Recommendation Report for Planning Permission for Works or Extension to a Dwelling

REF NO: BR/146/25/HH

LOCATION: 4 Gatehouse Mews
Sudley Road
Bognor Regis
PO21 1FJ

PROPOSAL: New entrance porch. Single storey rear extension. Conversion of existing storage room into habitable room.

4 GATEHOUSE MEWS, SUDLEY ROAD,
BOGNOR REGIS, PO21 1FJ
SHEET PL 105

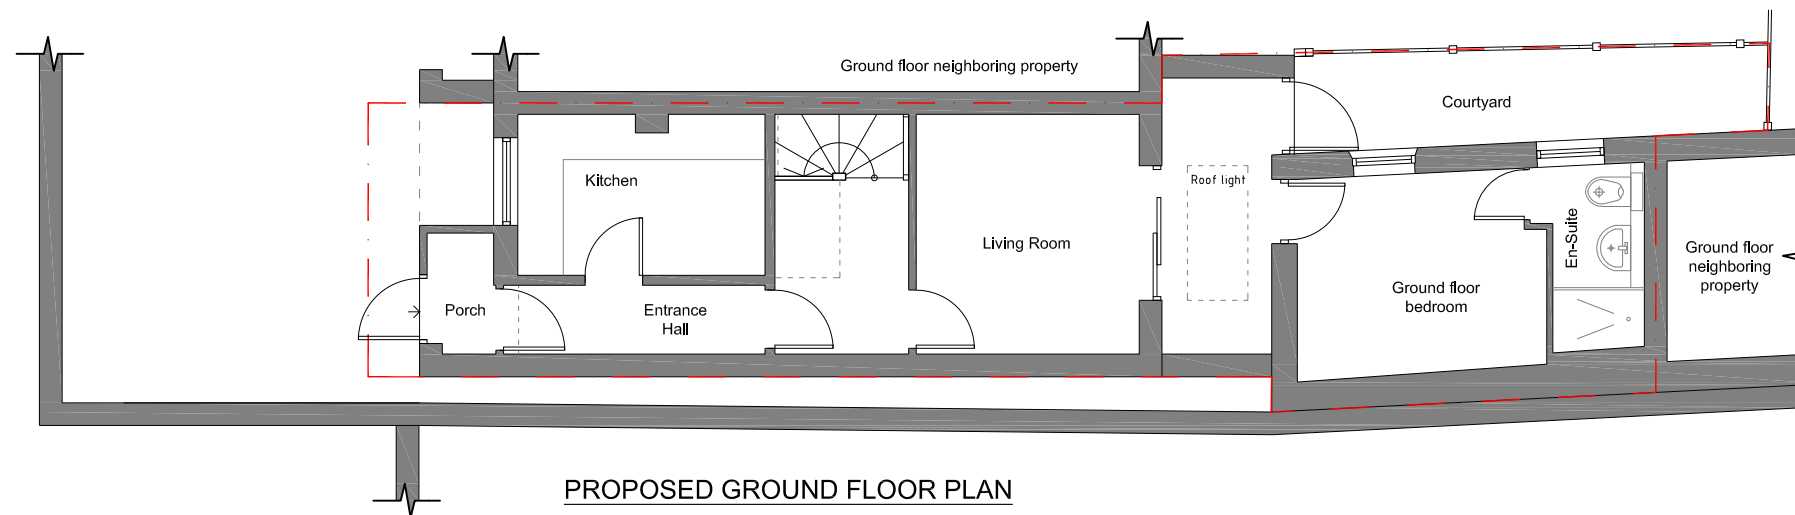
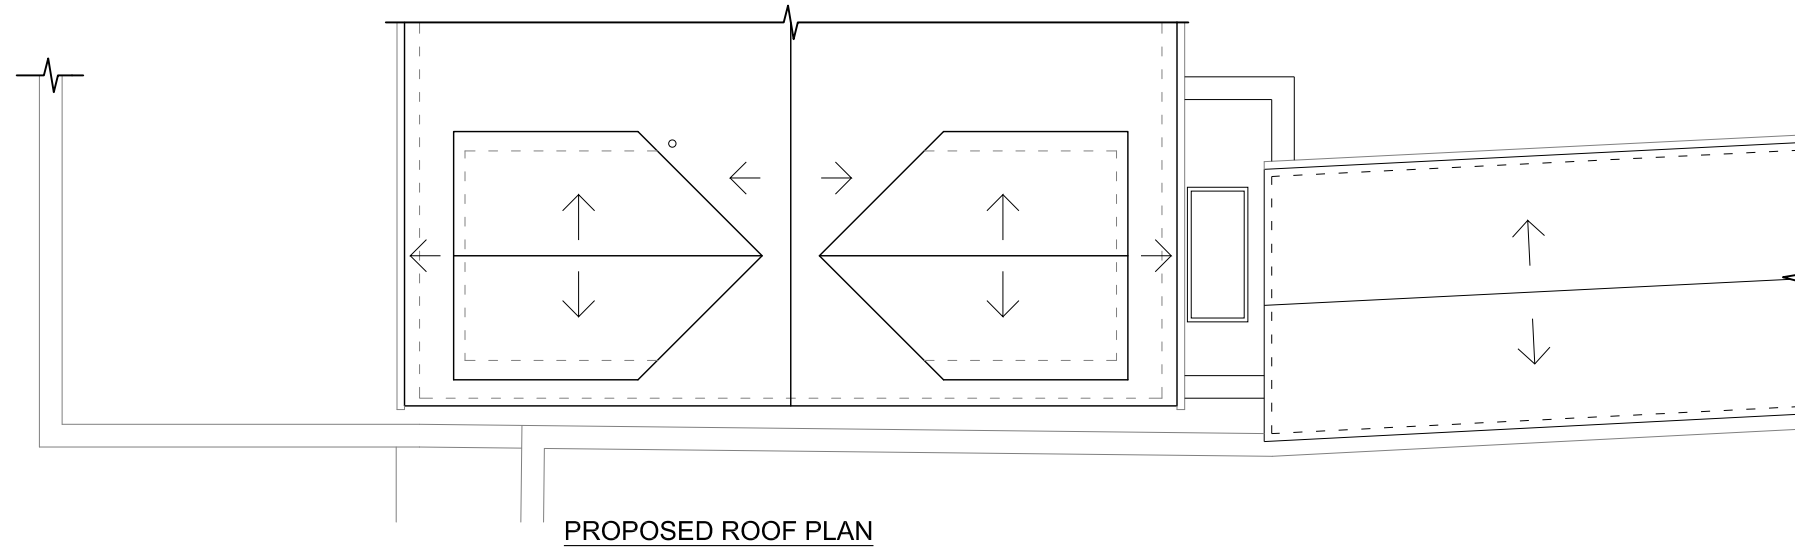
The proposed porch would adjoin the front elevation and would measure 2m wide, 1m deep and 2.2m high. It would be sited within an existing recessed area, as such it would not extend beyond the established building line of the dwelling and its attached neighbour. The proposed porch would not harm the character of the host dwelling or surrounding area in accordance with policy D DM1 of the Arun Local Plan (ALP).

The proposed conversion of the existing store within the rear garden would maintain the existing footprint, height, and design. The door on the north elevation would be replaced with a window to match the adjacent. As such, the proposed conversion would not impact the visual amenity of the host dwelling in accordance with policies D DM1 and D DM4 of the ALP.

The proposed single storey rear extension would measure 1.7m deep and 4.2m wide, with a flat roof height of 3.1m. It would provide a link between the rear elevation of the host dwelling to the existing store within the rear garden. The extension would be finished with matching brickwork to the host dwelling. Fenestration to the rear elevation would comprise a door to the rear garden and one rooflight is proposed within the flat roof. The proposed extension would not adversely impact visual amenity in accordance with policies D DM1 and D DM4 of the ALP.

The proposed store conversion would retain its existing depth, width and height and would be used as a bedroom. The proposal would maintain its existing siting, adjoining the neighbouring dwelling to the south-east, abutting their ground floor amenity. Whilst it is noted that the garage is currently not in habitable use, the conversion of the garage to a bedroom would not result in significant noise or disturbance, or any overbearing or overshadowing impacts to the neighbouring dwelling. The existing door would be replaced with a window and would give rise to views of the rear garden, views obtained would not be significantly different to those currently achieved from the existing adjacent window. As such, the conversion would not result in harmful overlooking.

The proposed single storey rear extension would be constructed up to the side boundaries. To the south-west, the existing wall projection would be 0.7m higher than the extension as such, there would be no overbearing or overshadowing impacts to this neighbour. To the north-east, there is an existing 1.8m boundary fence. The extension would project 1.2m above the fence and would have a modest depth of 1.7m. Due to its limited depth and single storey scale, the extension would not result in unacceptable loss of light or overbearing impacts. No fenestration is proposed within the side elevations, ensuring that the proposed single storey extension would not result in any overlooking impacts to either neighbour.
